**ADC Planning Consultation
Response from the Historic Buildings Adviser**

Application Number	WA/24/14/L & WA/23/14/HH
Address	The Glebe House, Binsted
Description	Link extension, new door and window, internal alterations.
Case Officer	James Smith
Site Visit	28 May 2014

No Objection subject to amendment

13574/ 04

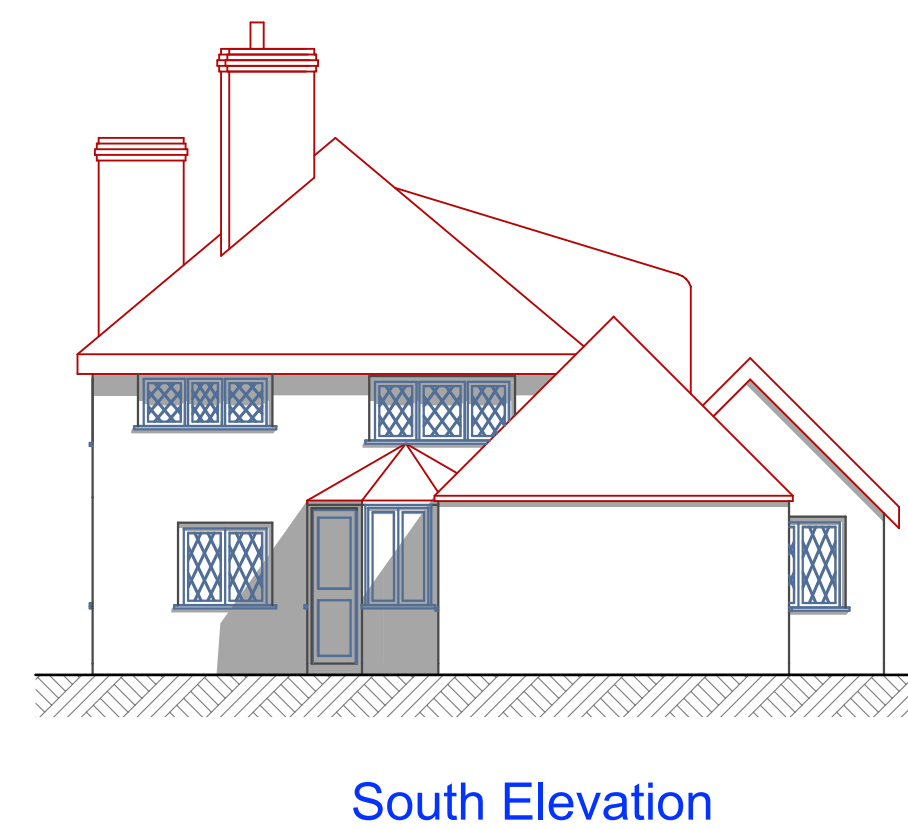
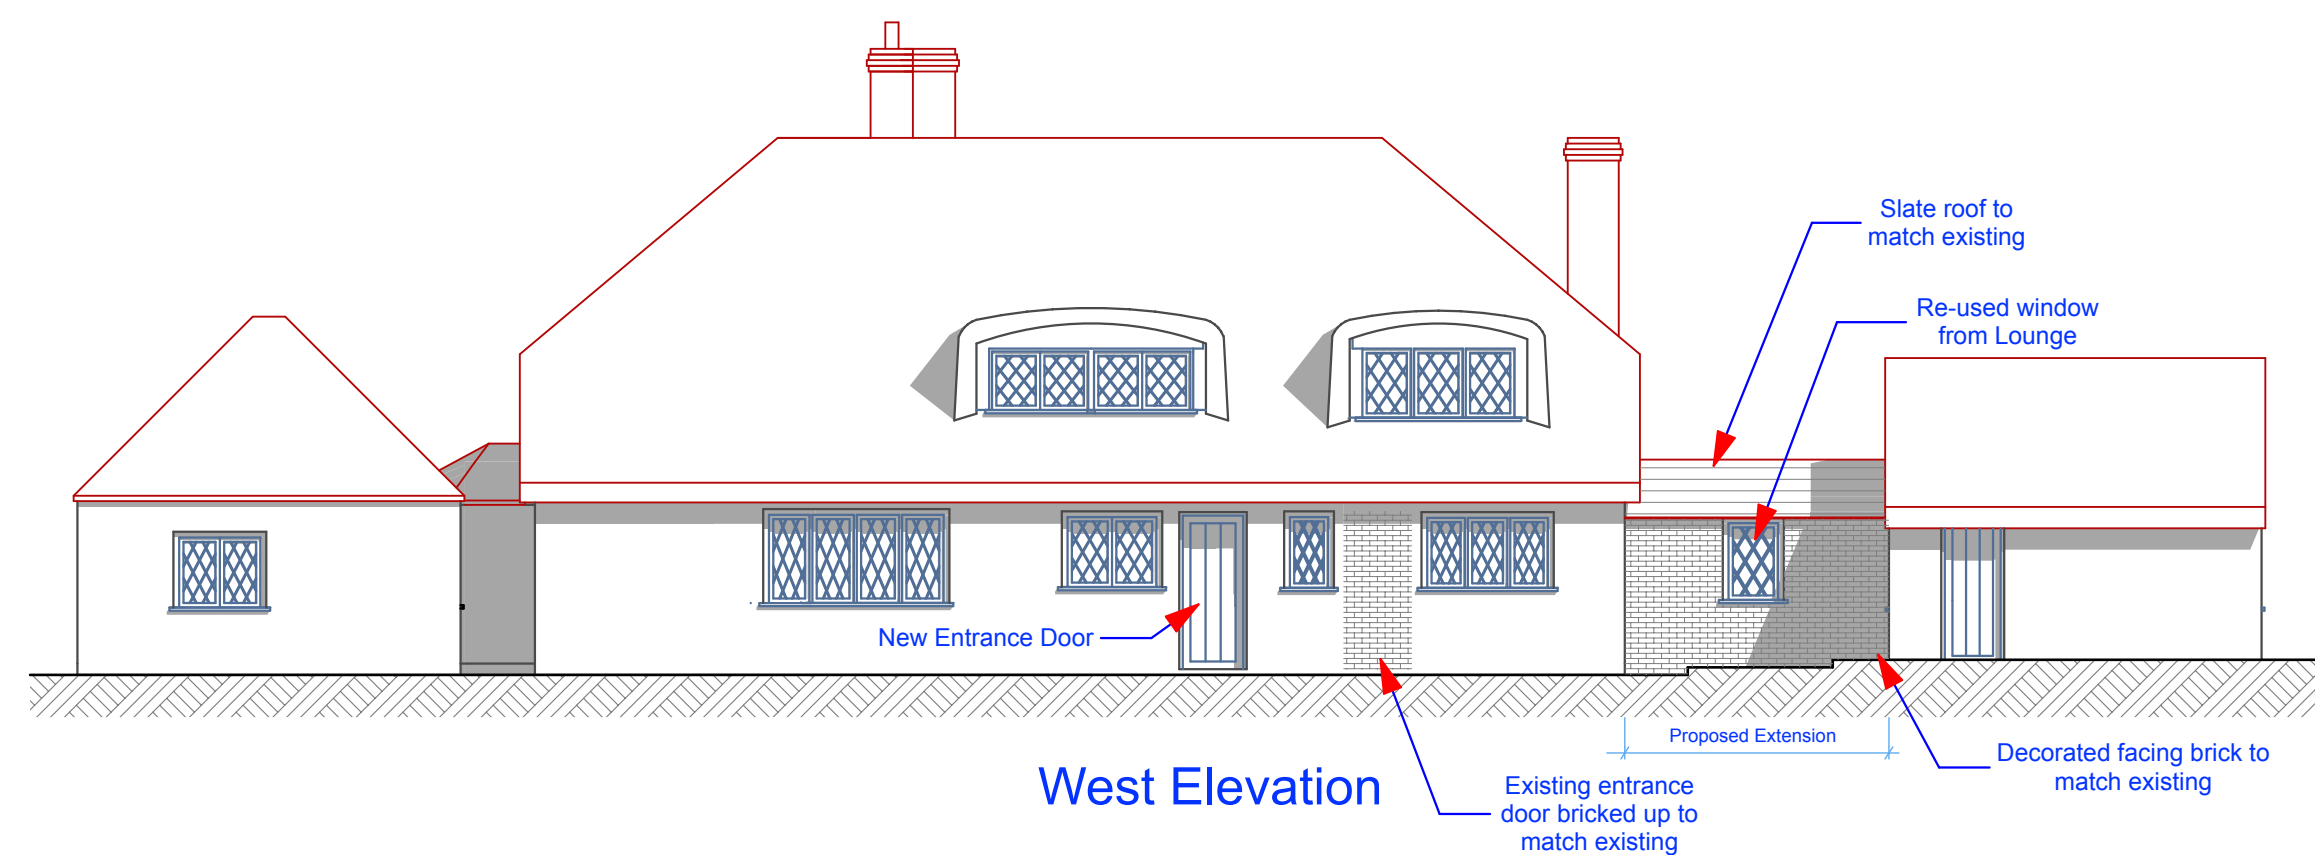
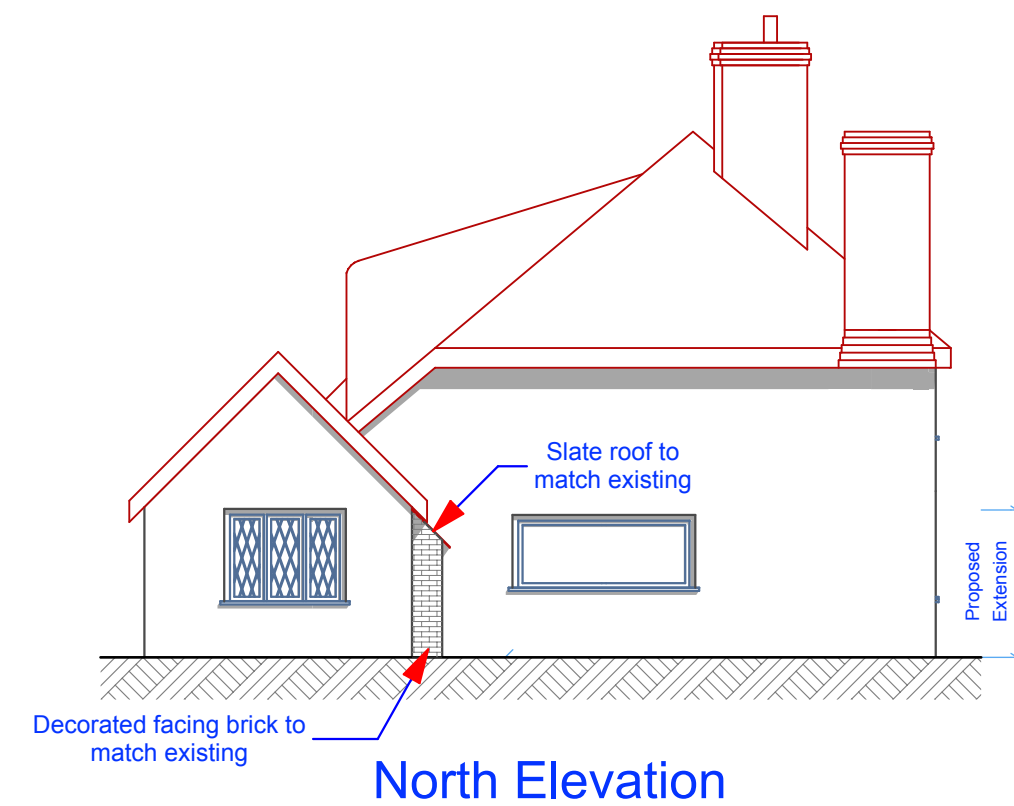
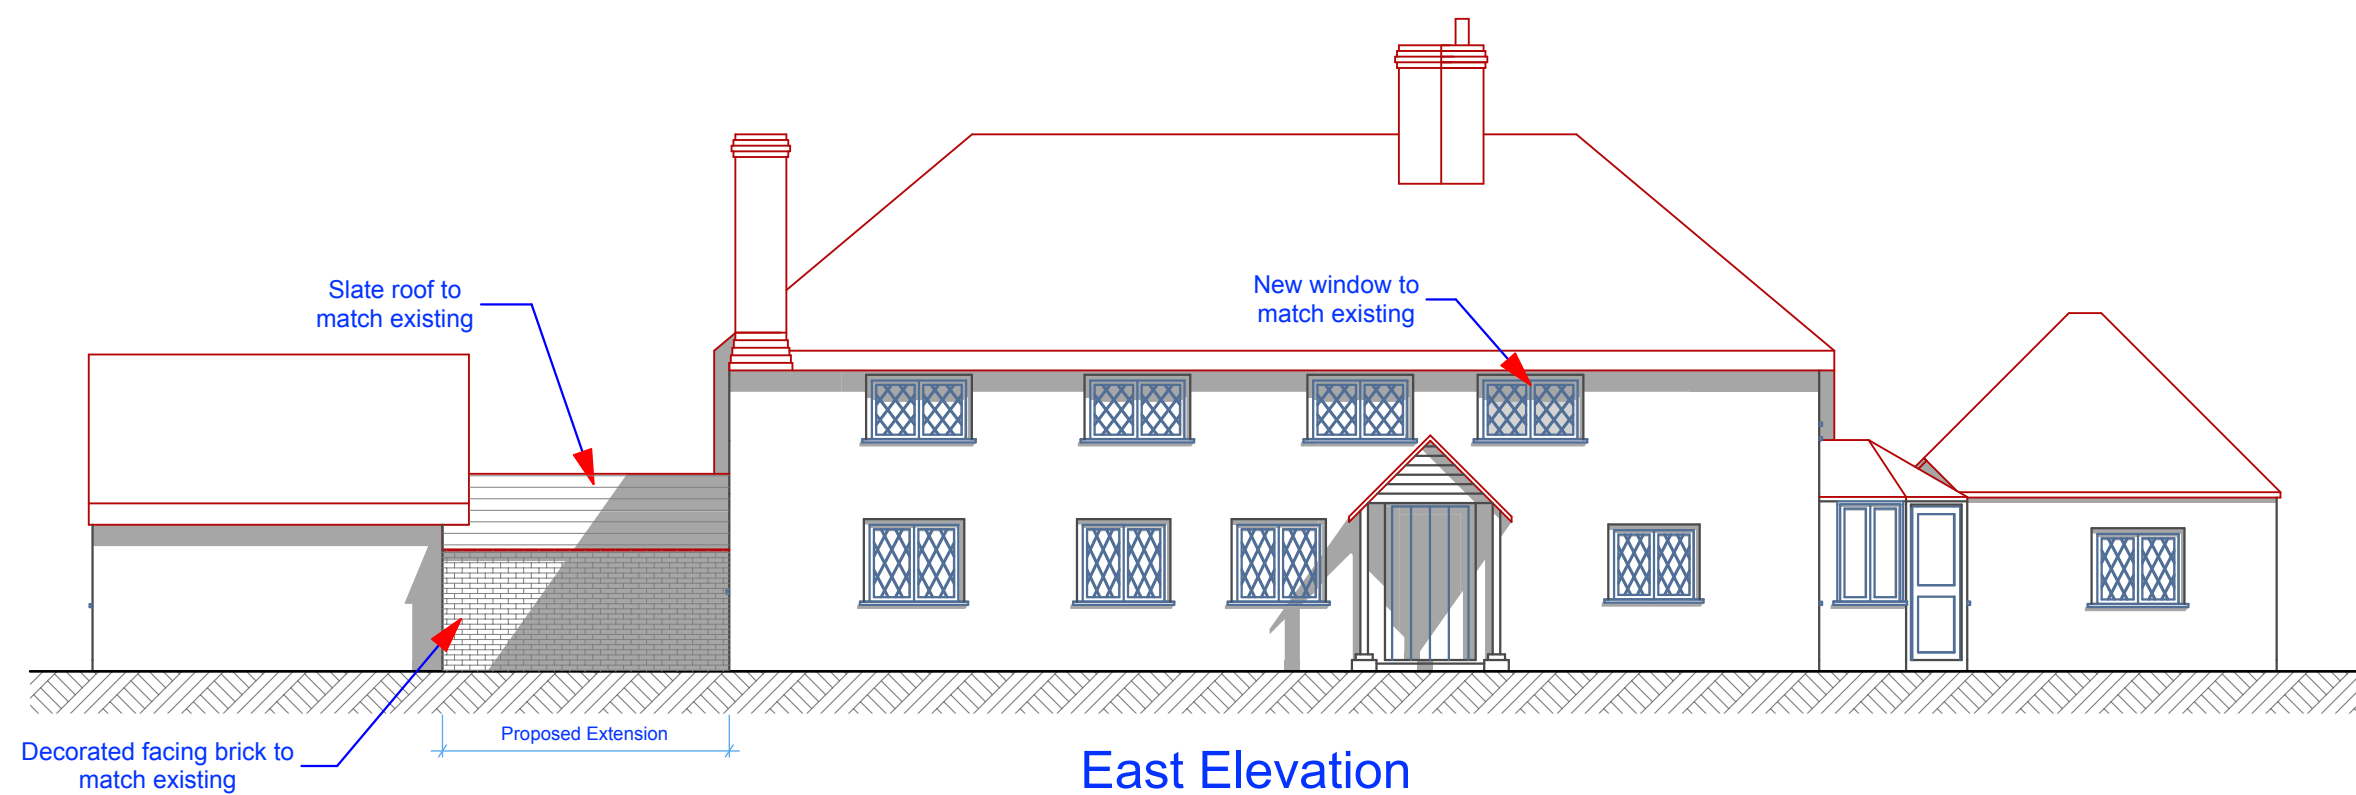
The location of the proposed link currently has a brick wall and opening and a structure built onto the east side. These are not particularly sympathetic additions so their removal would not be an issue. The proposed link here should potentially improve this, however as viewed from the east, it is shown encroaching over the corner of the coal shed, when ideally it should only abut its north elevation. It also protrudes to the east when it would appear more sympathetic flush with the outbuilding. We would also recommend that the link be timber to express a softer, more subservient connection with the two masonry and more prominent structures.

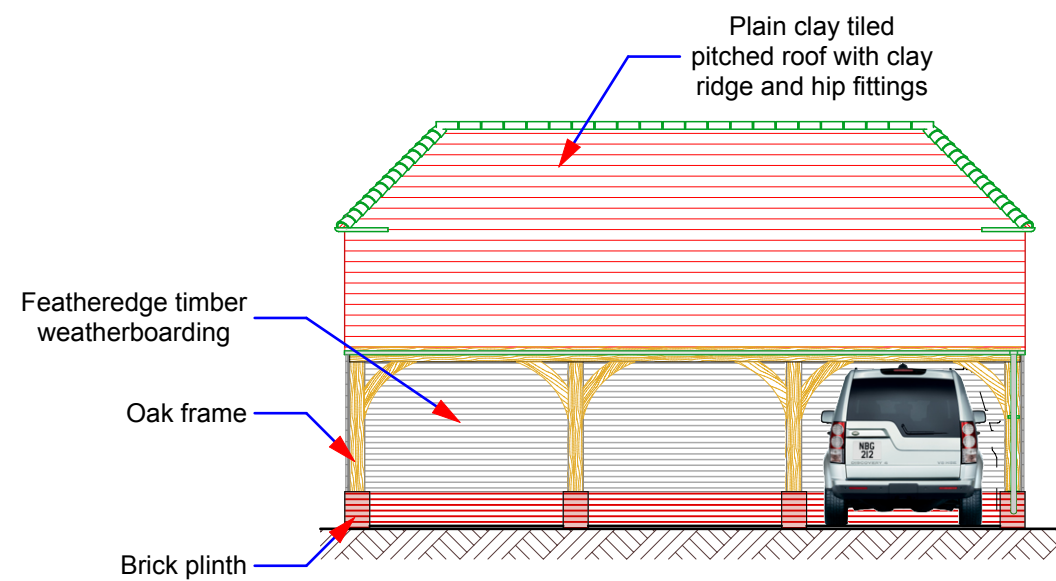
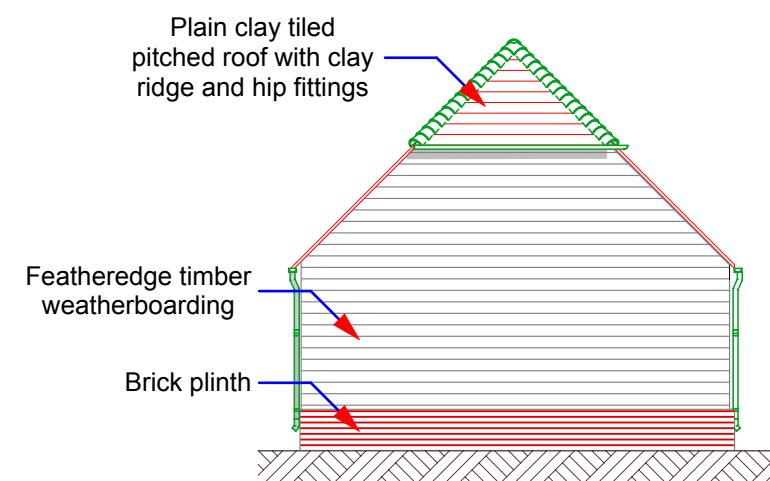
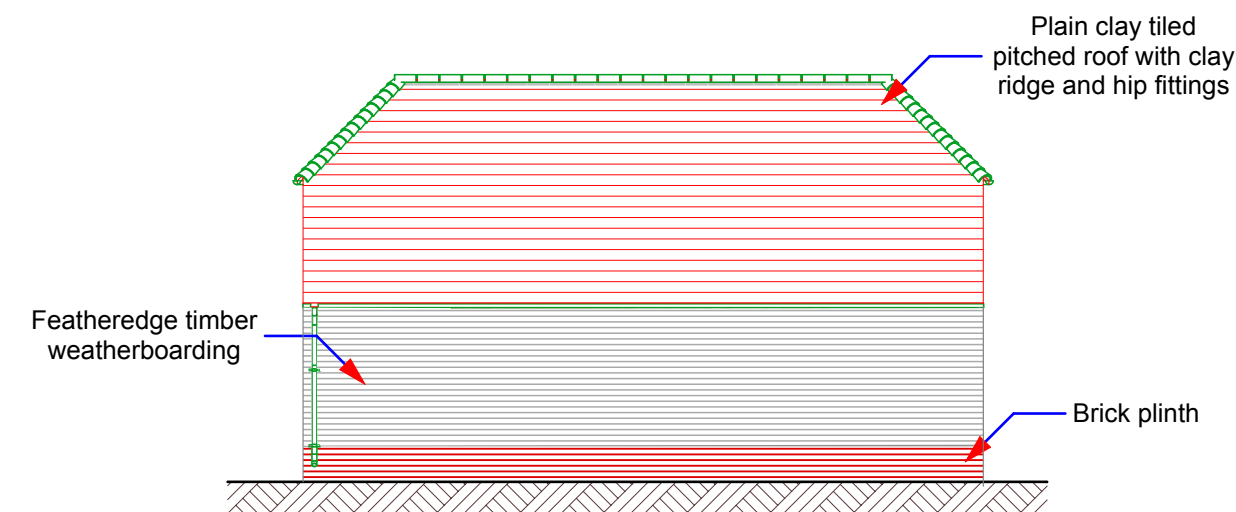
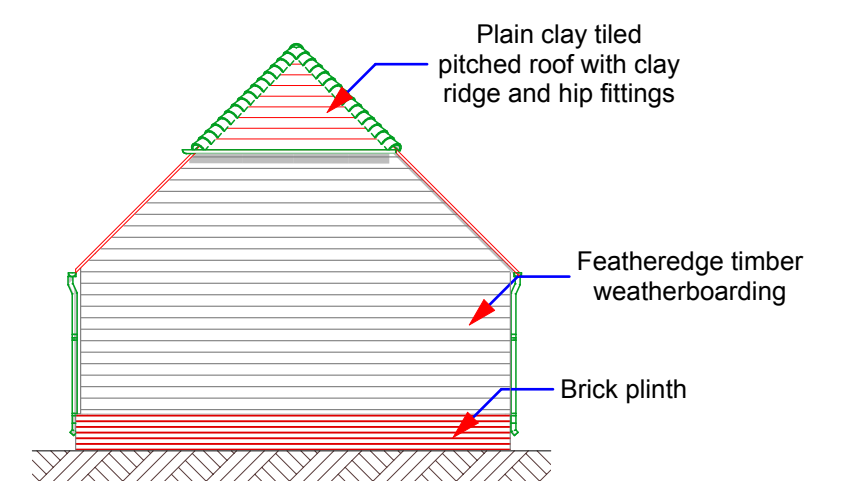
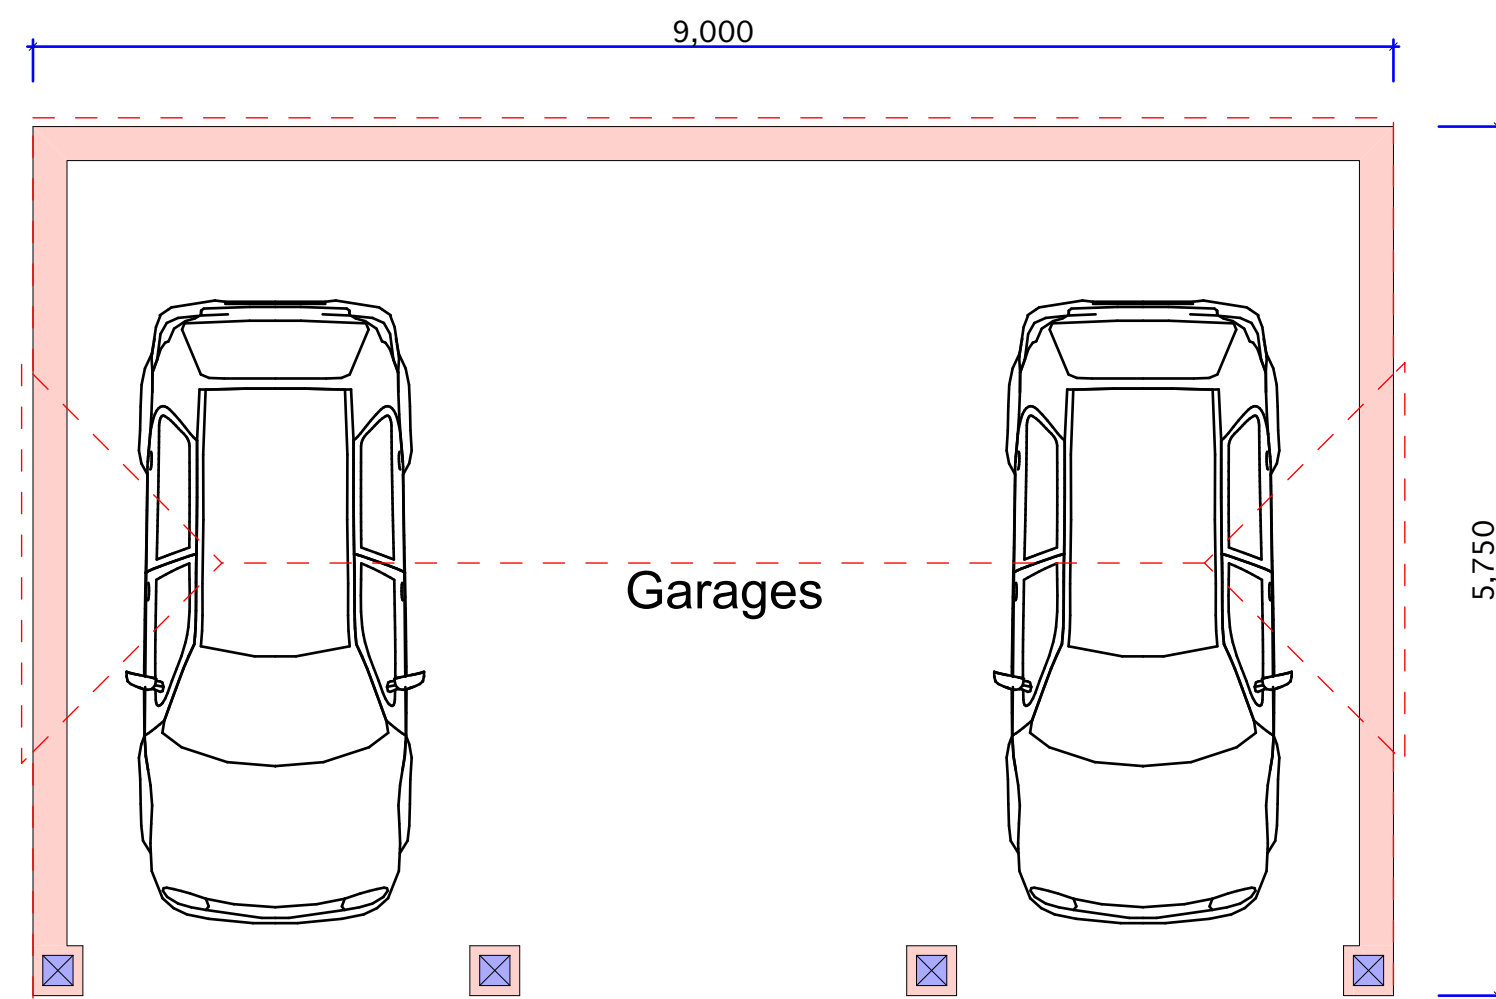
With respect to the garage, the principle of a structure here is acceptable, however we would question the use of a purely timber building here. As a rule, the majority, if not all historic outbuildings in the immediate area, appear to be brick or brick and flint. Pure timber buildings are more common in other areas such as the weald, but not so much here. On this basis we would ask if there is potential to have a part masonry and part timber building which would better compliment the setting of the listed building and the surrounding historic environment.
